From: Peter Dixon [REDACTED]
Sent: 11 March 2018 19:36
To: Planning
Cc: Anita Gardner
Subject: Planning at 93 Middleton Road M/123/17/HH

GROUND FLOOR PLAN

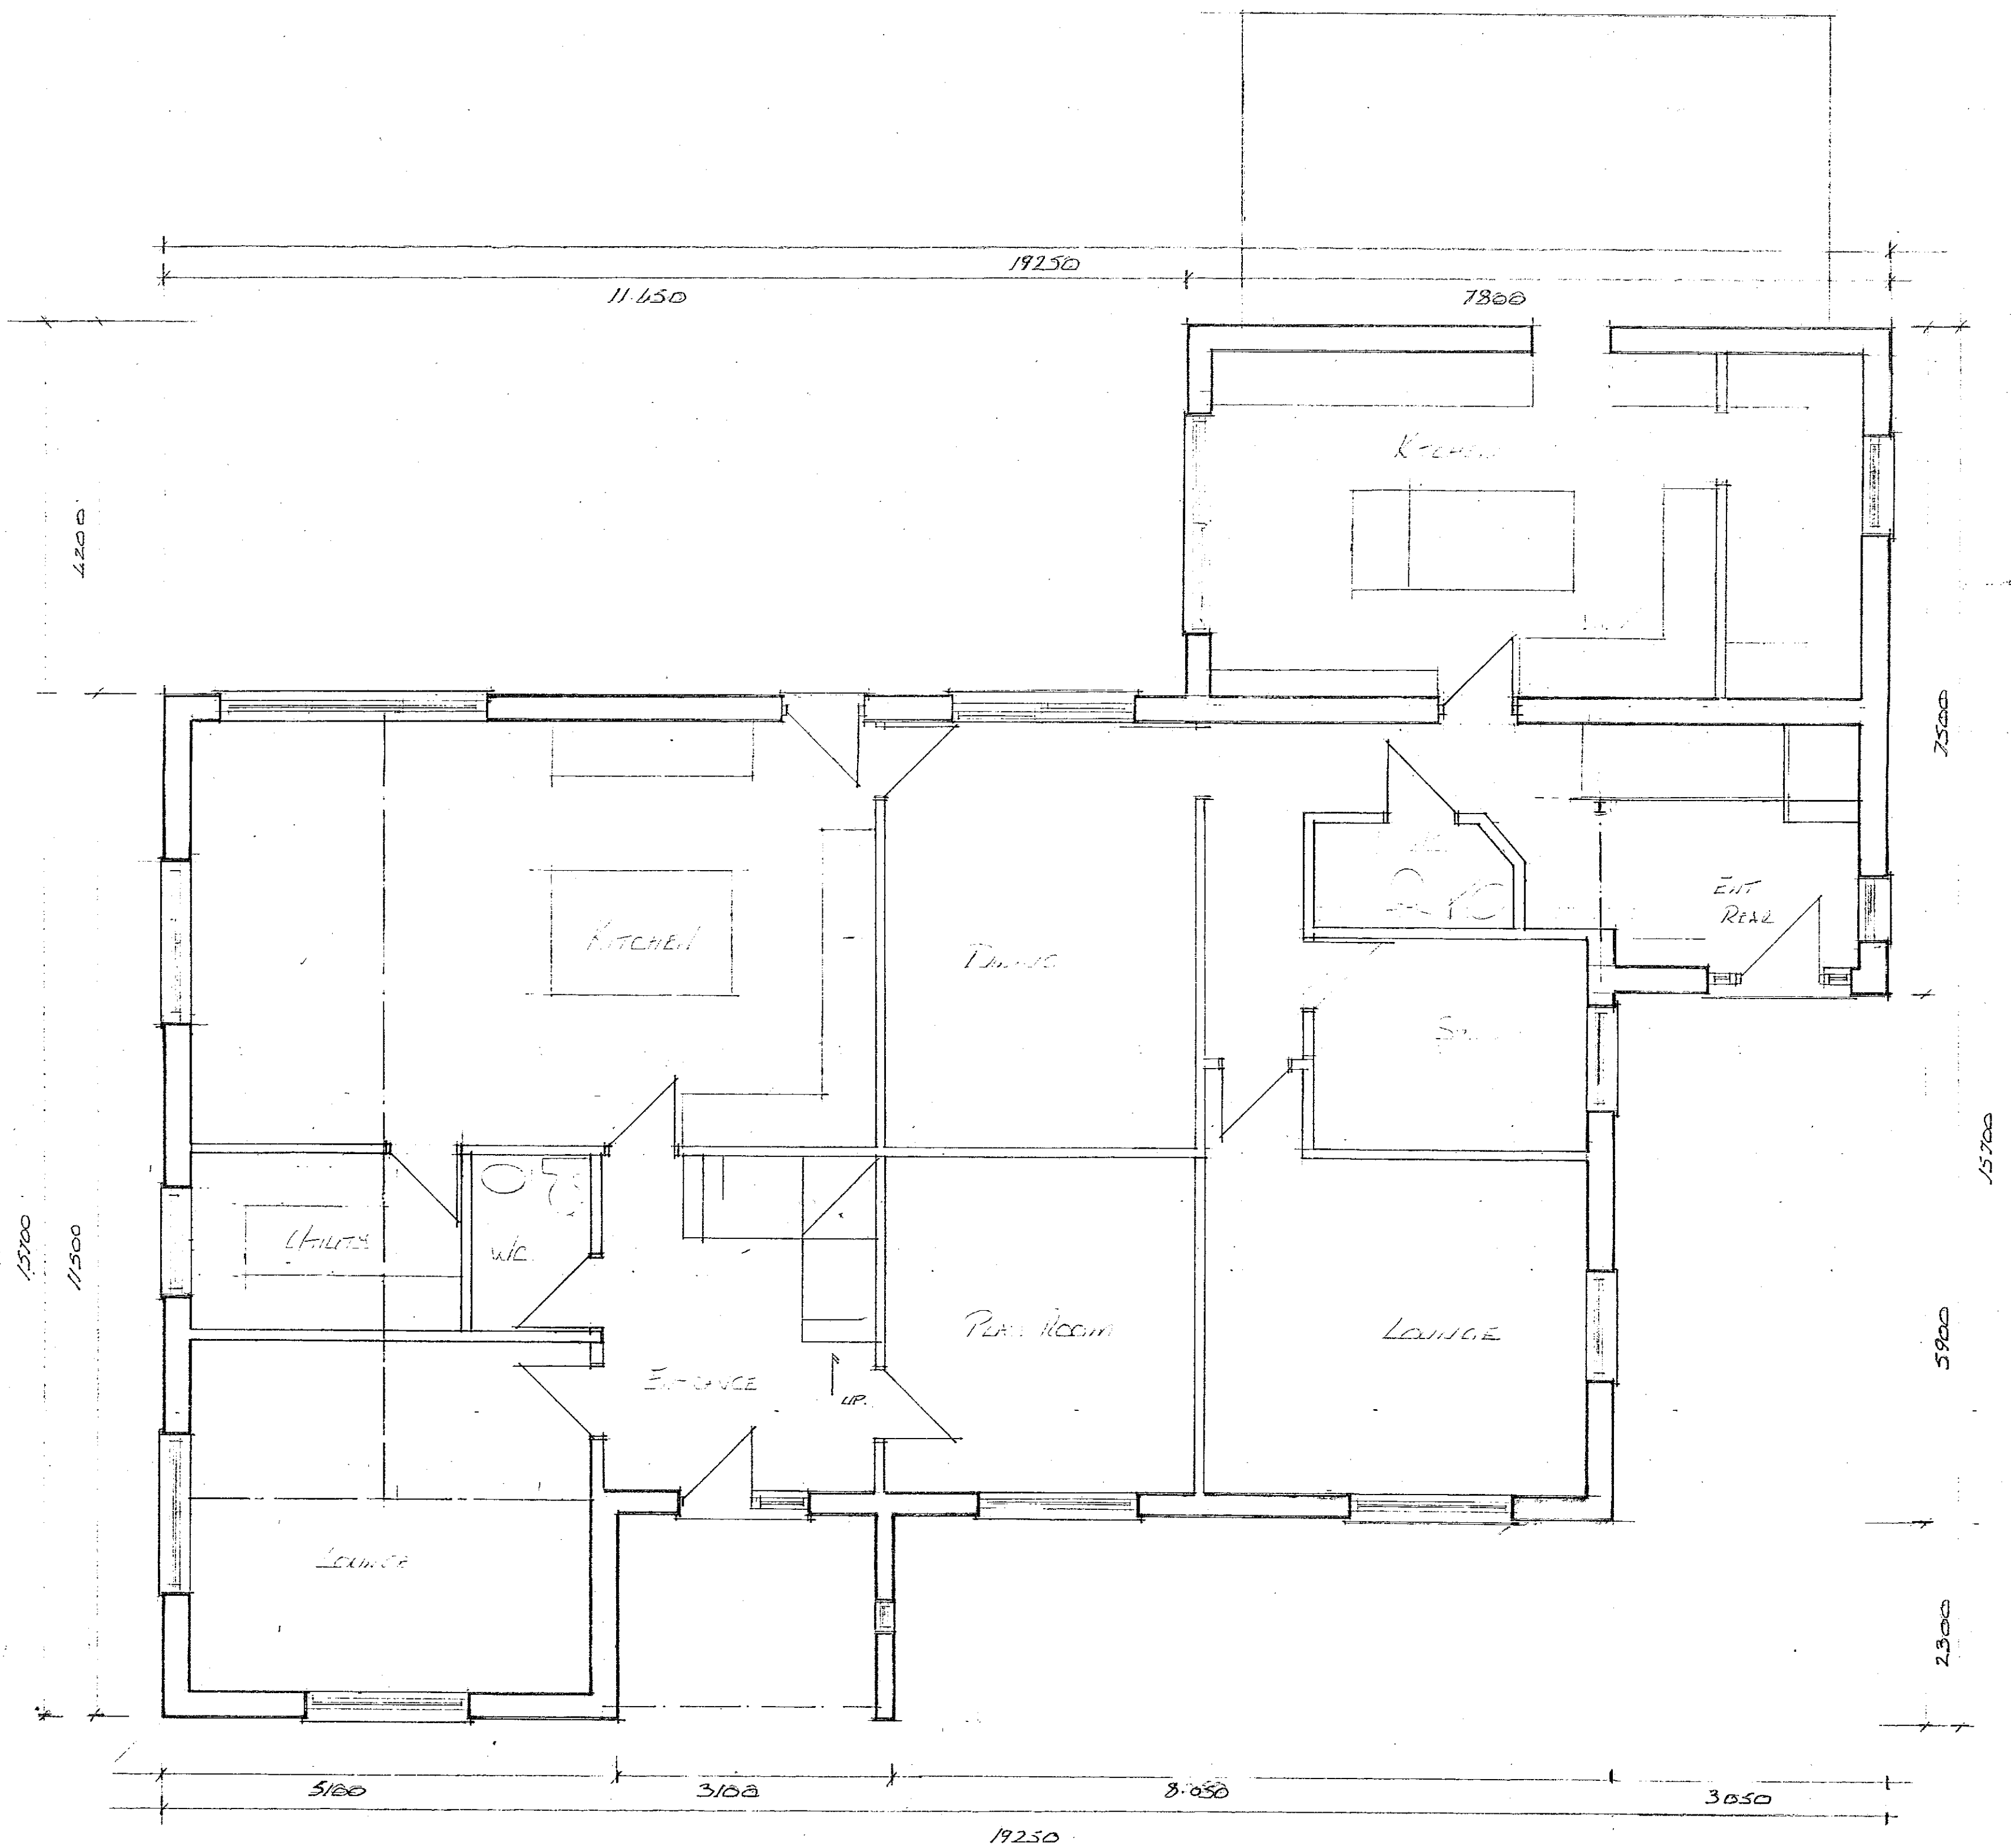
The left one is a new photograph and shows the current lounge extension at number 93 that is not currently shown on the dotted line included on drawing AB:100:12 Version 5
